**Consultation Response from KC,
Lead Local Flood Authority**

2024/93605 Land at, Main Avenue, Cowlersley, Huddersfield, HD4 5US

Erection of 57 dwellings with access from new through road connecting Main Avenue and Windsor Road, and associated works, including engineering and landscaping

Date Responded: 7th February 2025

Fig. 2.5 - Ordnance Survey, 25-Inch, Yorkshire CCLX.2, Revised: 1930, Published: 1932

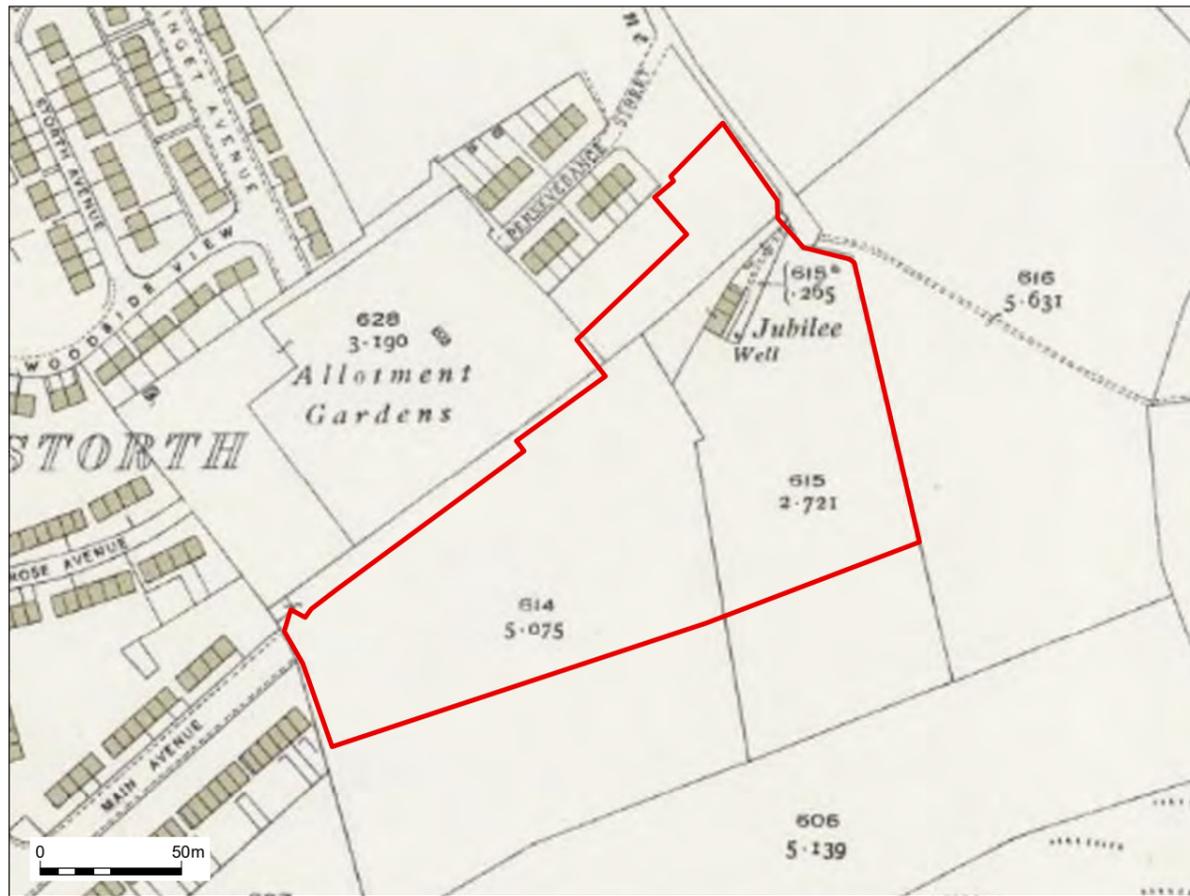
An examination of historical OS Maps shows a cluster of buildings toward the eastern boundary named 'Jubilee'. A well is clearly shown and in line with the downstream watercourse. The 1933 map is included as an example. Kirklees would like the applicant to determine the depth of the system as it leaves site and perform the excavation of slip trenches at the well location and upstream at several intervals including the western boundary with Main Avenue. Kirklees Council has previously noted overland flows (flows escaping?) along this low valley within the site in addition to water running south to north. The presence of existing systems must be fully investigated.

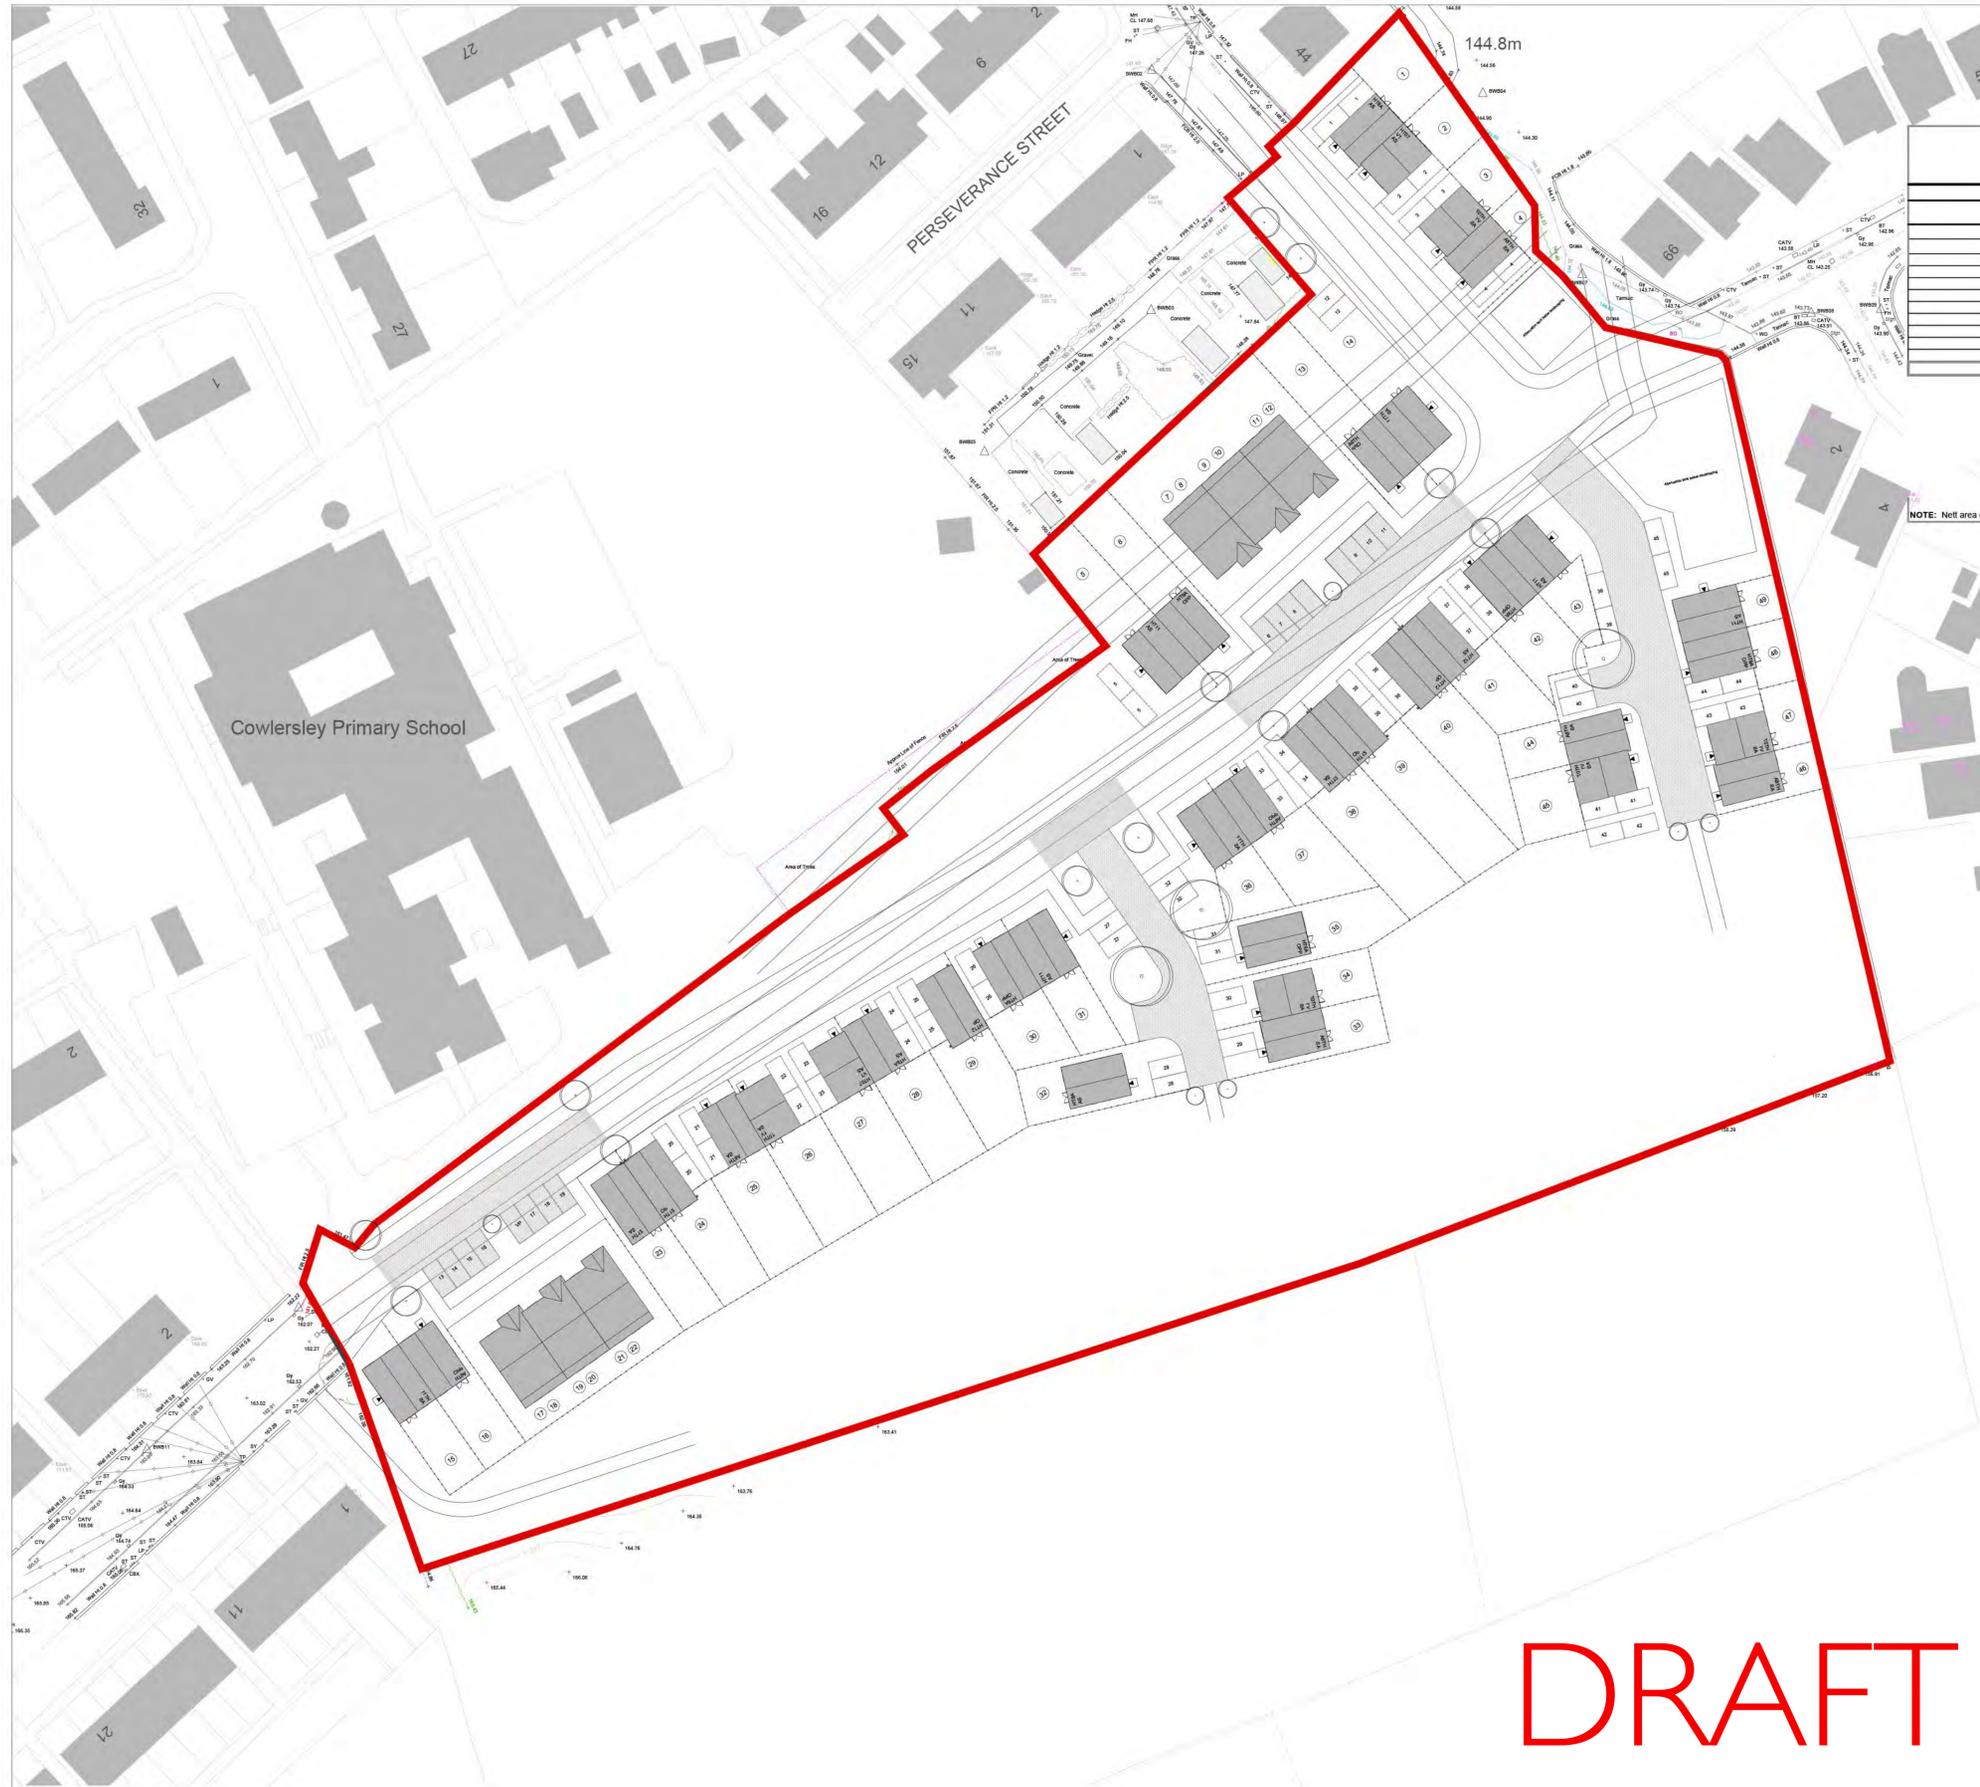
The LLFA is concerned about levels to the south of the development with a clear valley running toward retaining walls. This low spot does not coincide with the step identified as flow route. A layout review is required as should be the potential to include positive land drainage from the perimeter of the site.

Some plots on the northern side of the access road may need lifting slightly to ensure all driveways fall back toward to the road, in the interests of safe flood routing.
